Re: Status of Improvement Permit Application #17-5-42872

An attempt was made to evaluate your property for the purpose of issuing an Improvement Permit. The evaluation could not be completed for one or more of the following reasons.

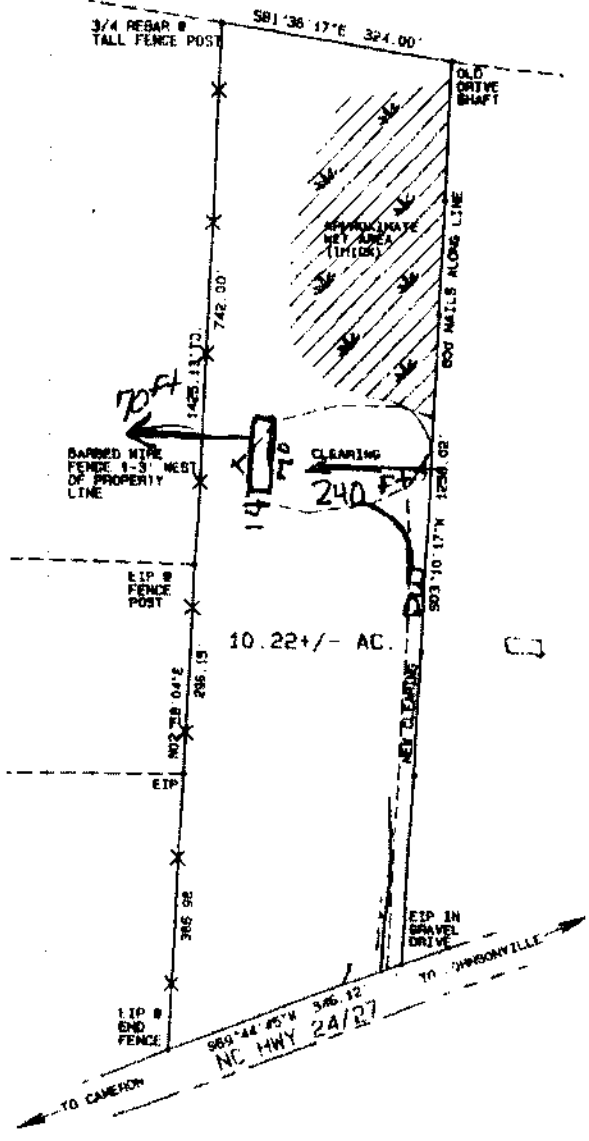
- 1. Use pink flags to mark property lines and irons that are set by surveyor need to be visible *(\$25.00 fee incurred)*
- 2. Use orange flags to mark house corners *(\$25.00 fee incurred)*
- 3. Directions not clear to property *(\$25.00 fee incurred)*
- 4. Property needs only brush or vegetation removed
- 5. Driveway not shown on site plan
- 6. Backhoe pits required
- 7. Other – Revision required for side setback from 132 feet to approximately 65-70 feet.**
